RFI #: 77  
 Date: 3/15/2012  
 Job: EB-02 Keller Springs Lofts  
 Phone: 877-777-5115

CC: Erik Eamshaw (BGO)  
 Subject: Conflicts with meter center locations and numbers

RFI #: 96  
 Date: 3/28/2012  
 Job: EB-02 Keller Springs Lofts  
 Phone: 877-777-5115

CC: Erik Eamshaw (Beeler Guest Owens Architects)  
 Subject: Meter Center Locations

SHEET NUMBER
3.1C
BLDG PLAN 'C'

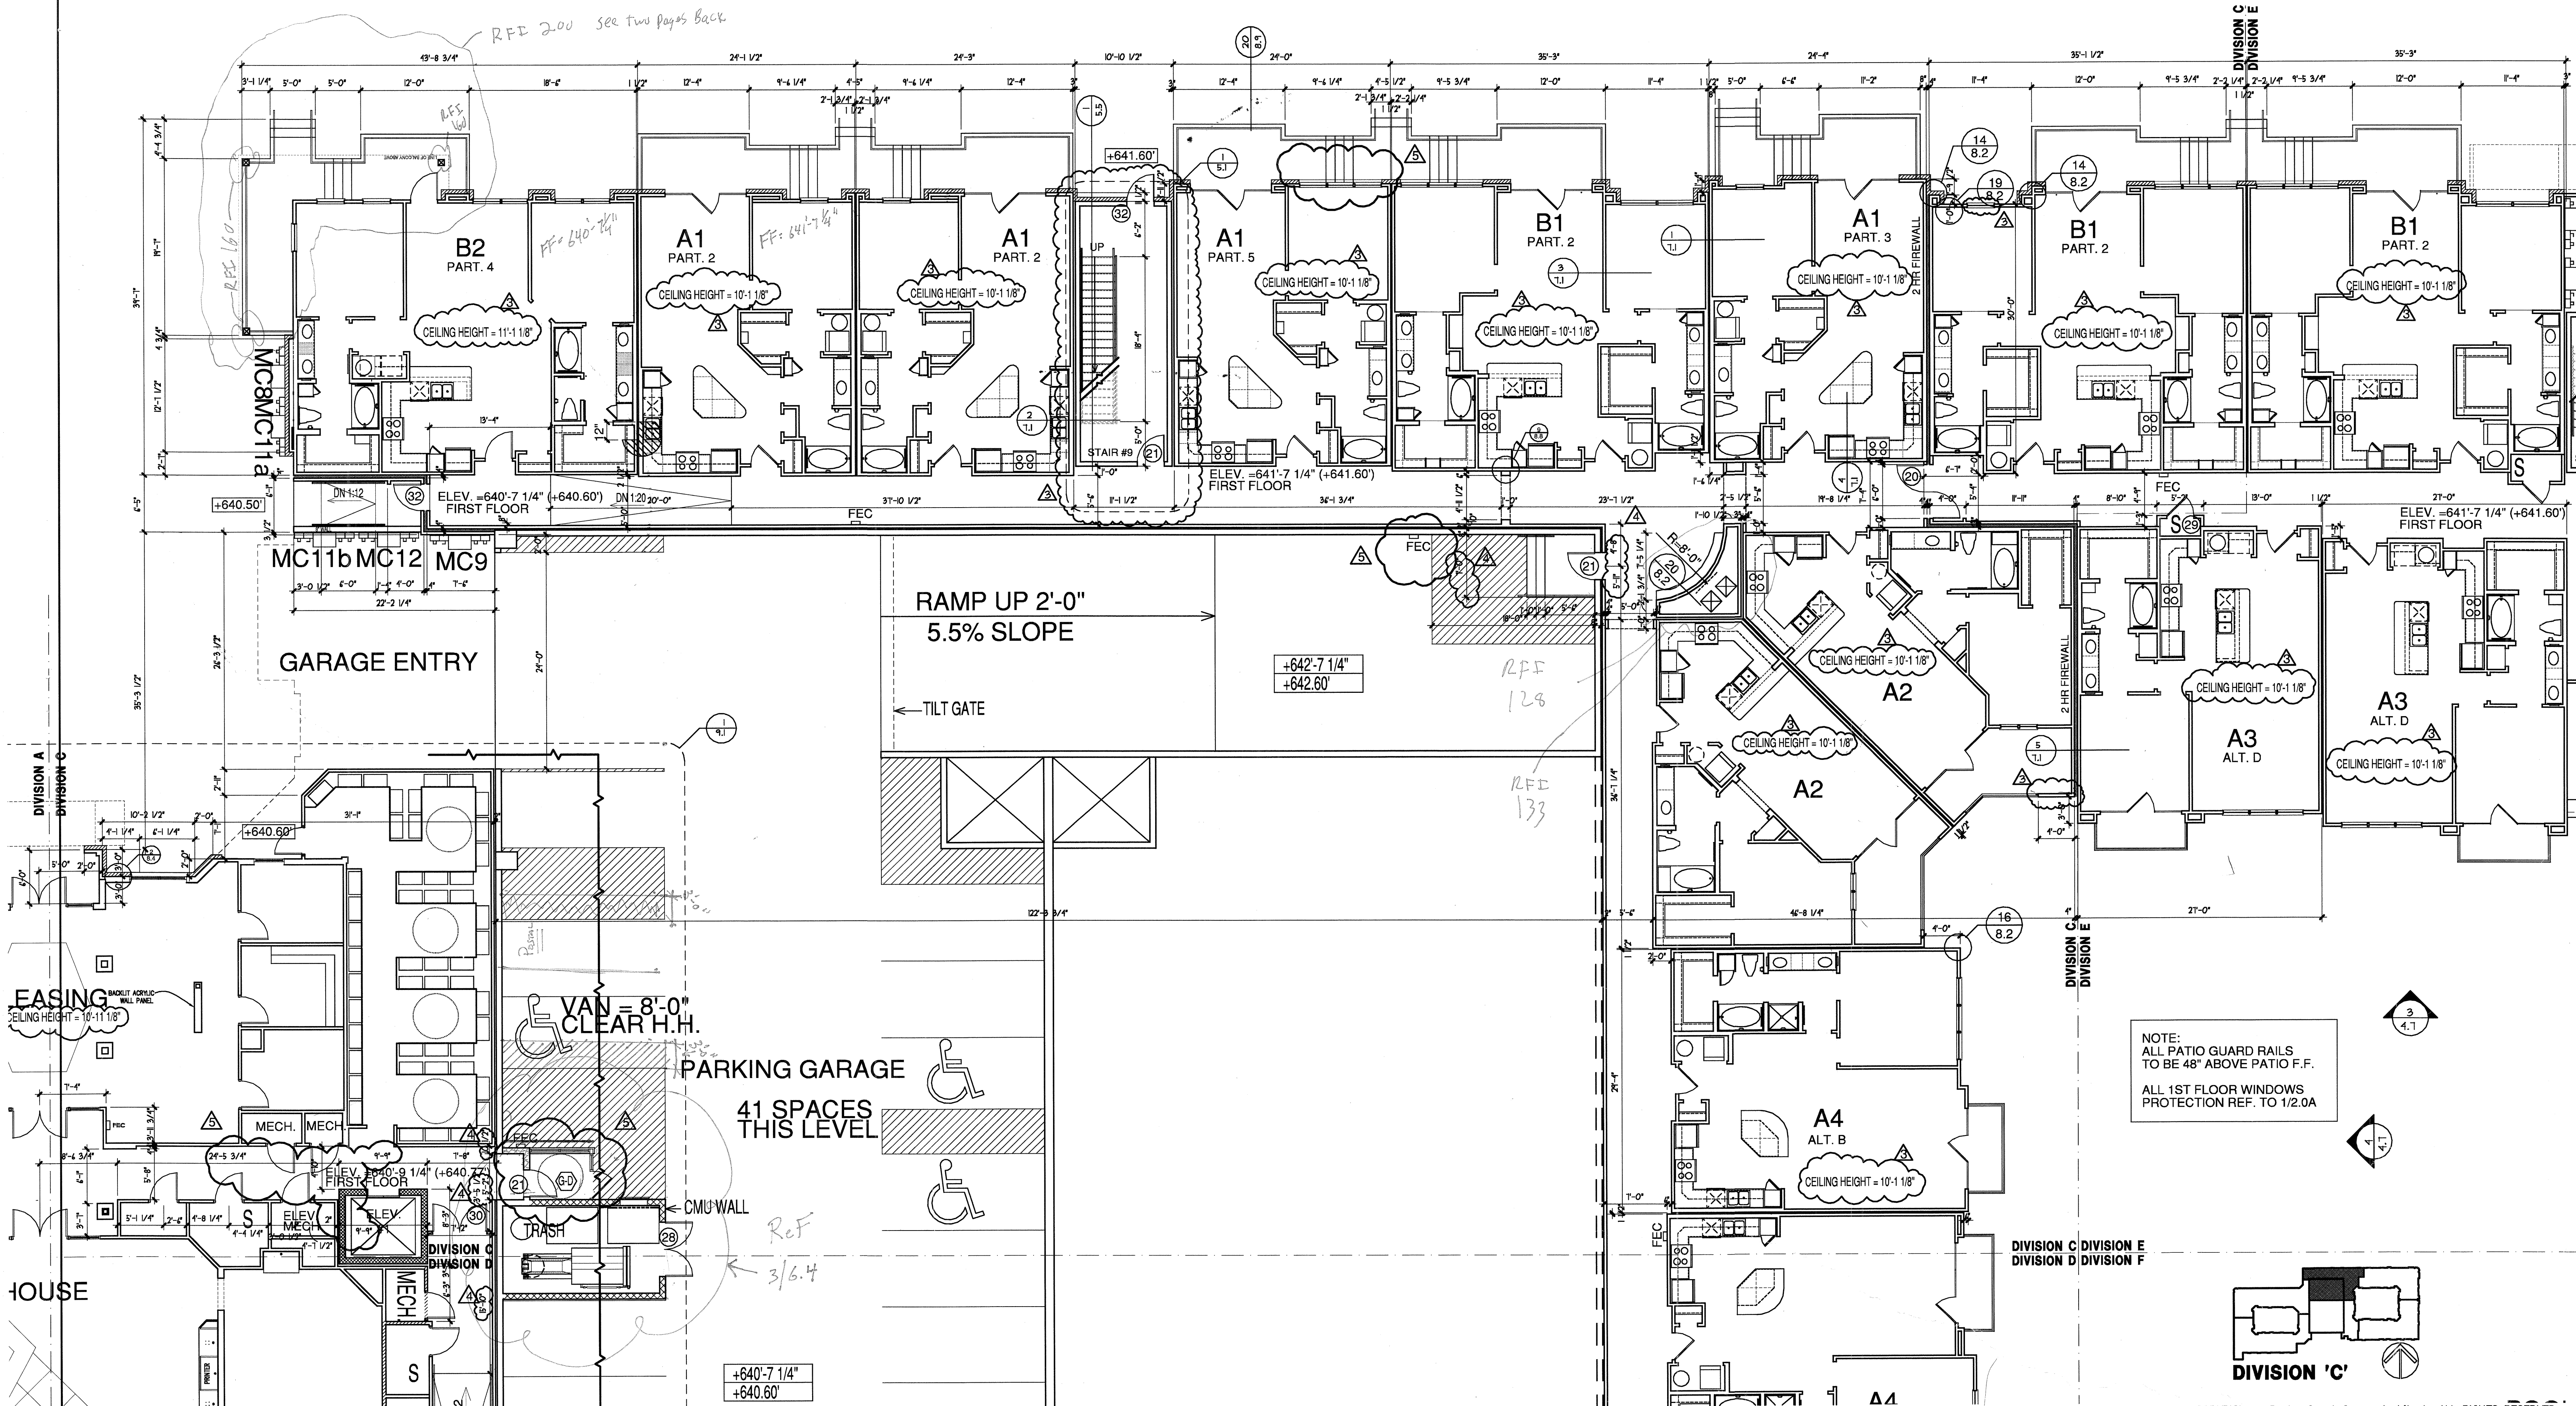
**Request:**  
 Some of the meter centers have changed location and numbers. 3.1C in Architectural and E-3.1C have different meter center numbers than the final E-10.1 and oncor final drawing. Also, E-10.1 and Oncor show two meter centers inside the garage. This must be a mistake. The meter centers should be mounted to the exterior of the building as shown on 3.1C and E-3.1C. I think we may want to have the meter center numbers match the Oncor plans and change from 3.1C and E-3.1C. These conflicts are very confusing and need to be corrected so we get them in the right place. Please see attachments and advise.

**Response:**  
 The meter centers were updated as part of rfi 96 on March 30th. The meter center names shall match those shown in the rfi 96 response. See attached for rfi response and updated drawings.

ELECTRICAL SITE PLAN

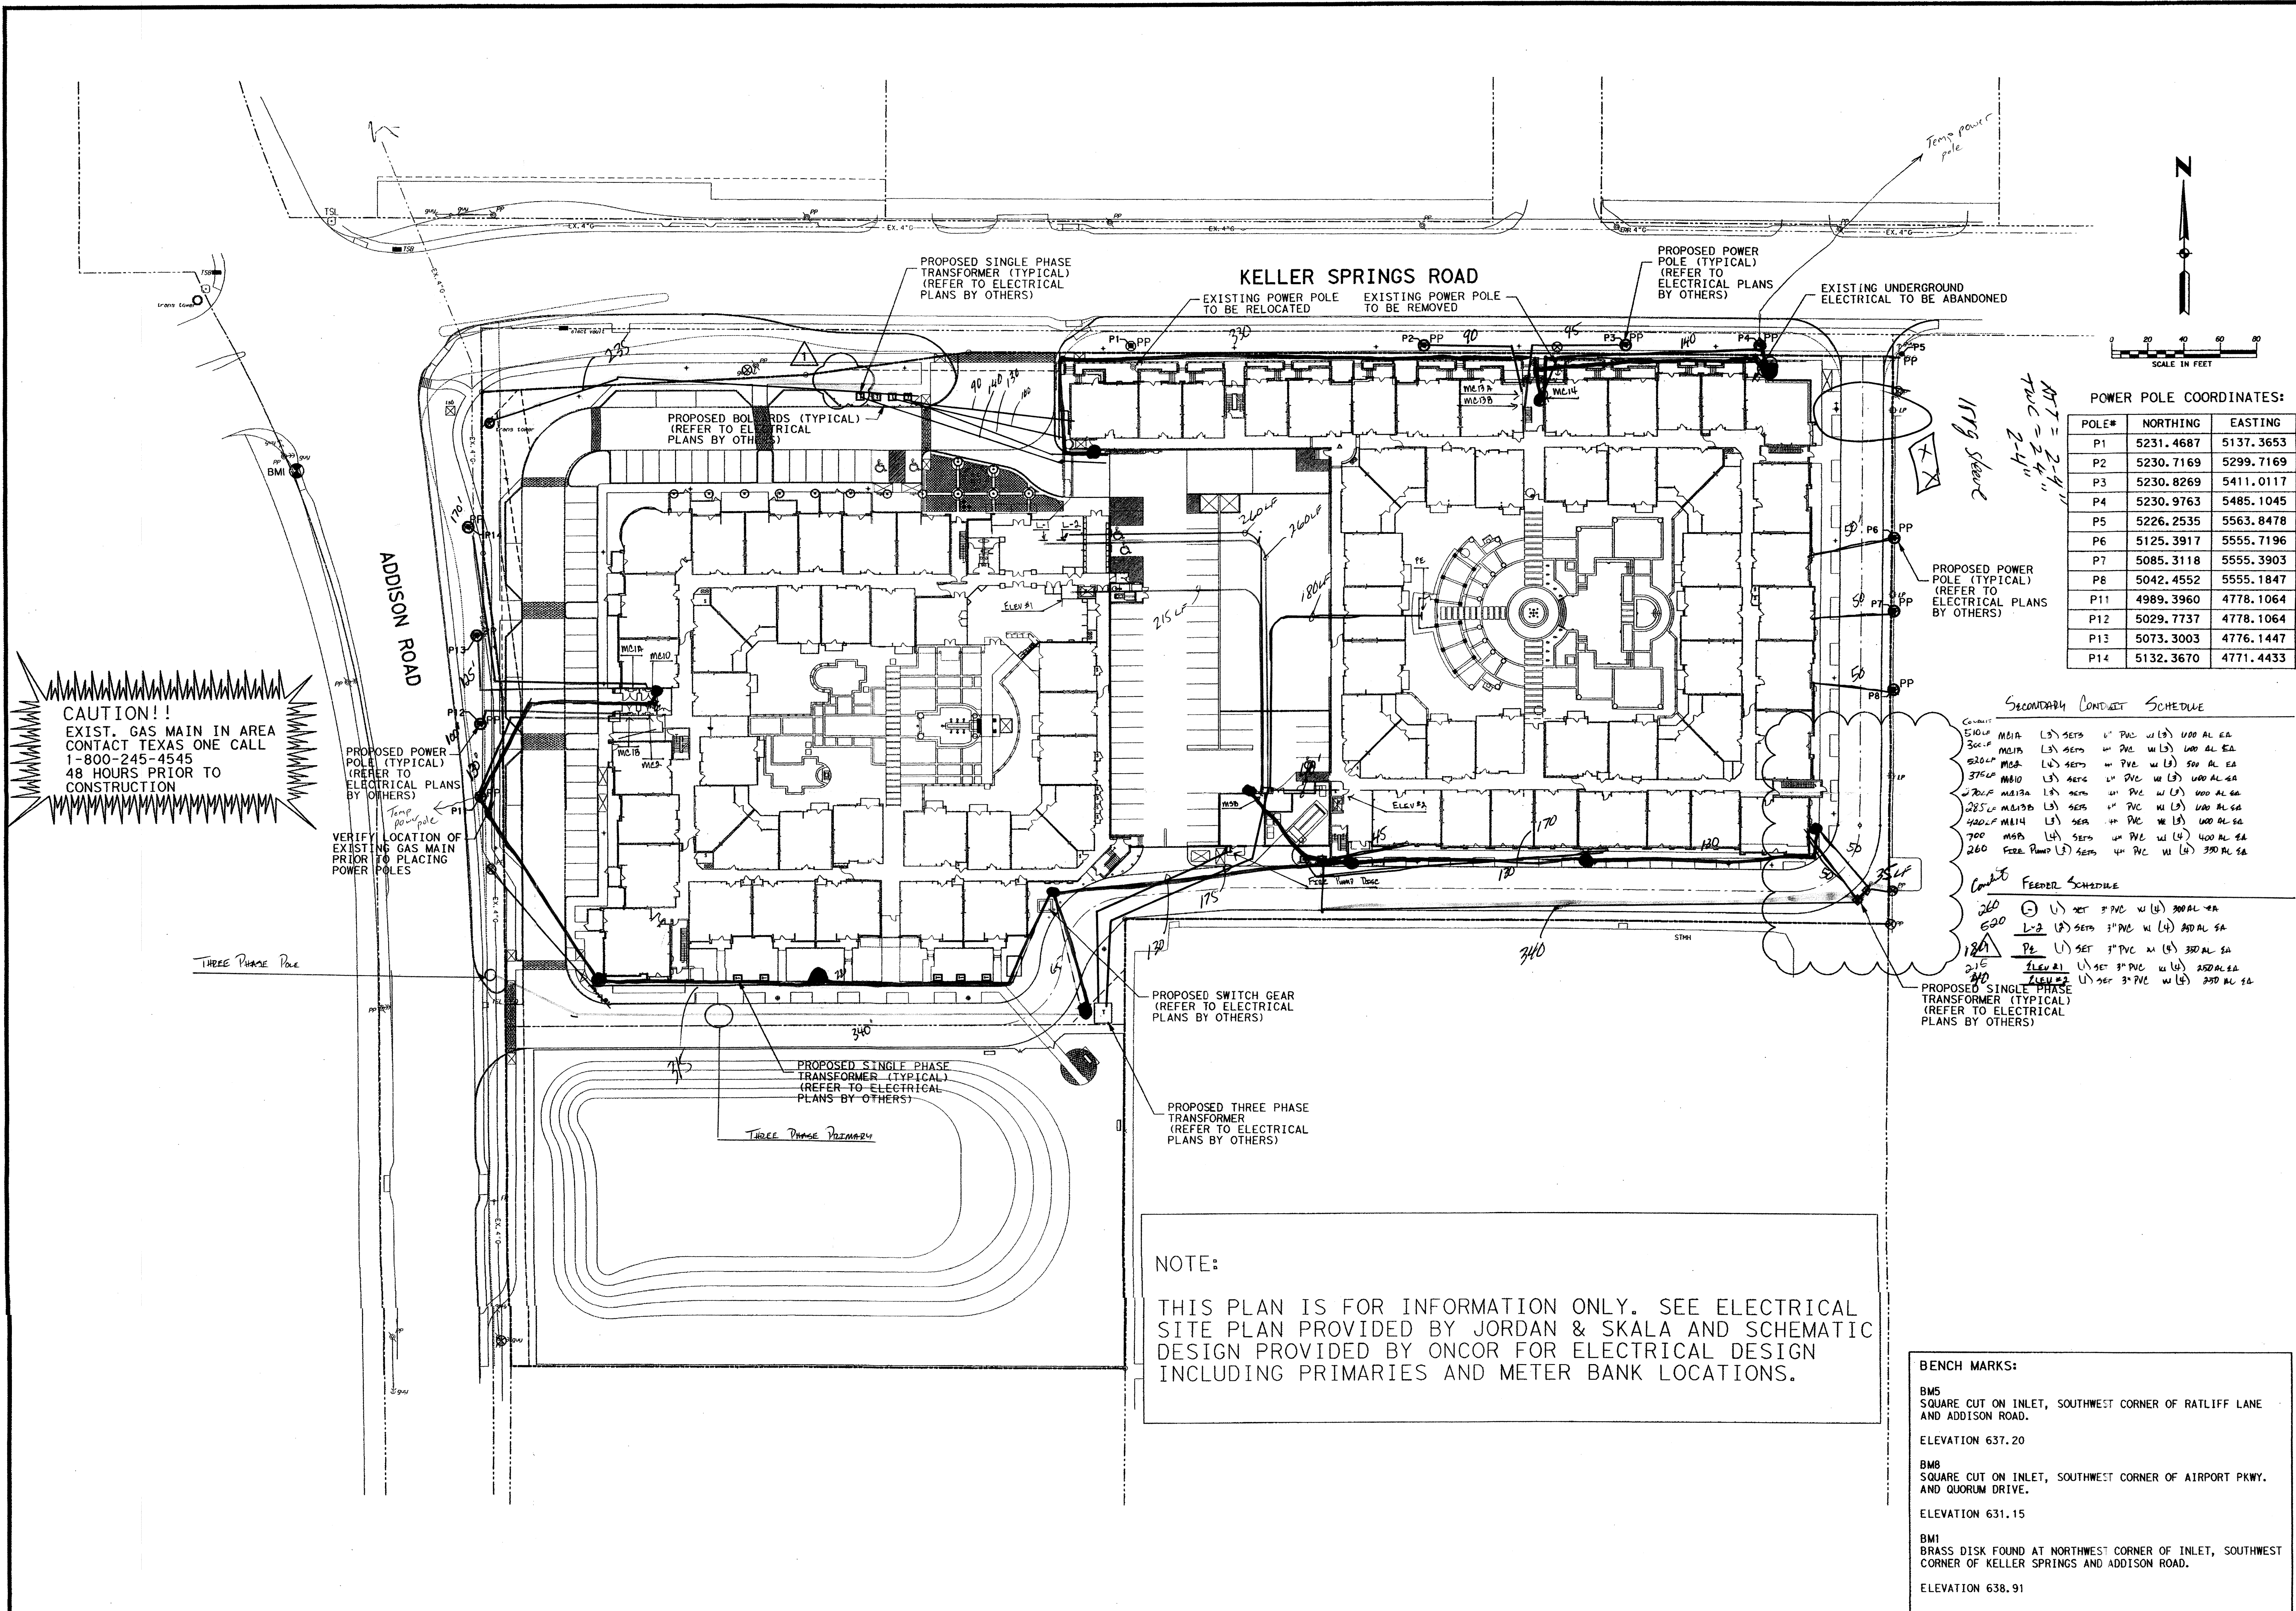
**Request:**  
 Has the electrical switch gear on sheets E10.1 and C 10A been Eliminated?  
 Date Required: 12/21/2011

**Response:**  
 The latest Oncor plan made available to JSB does not show switchgear.
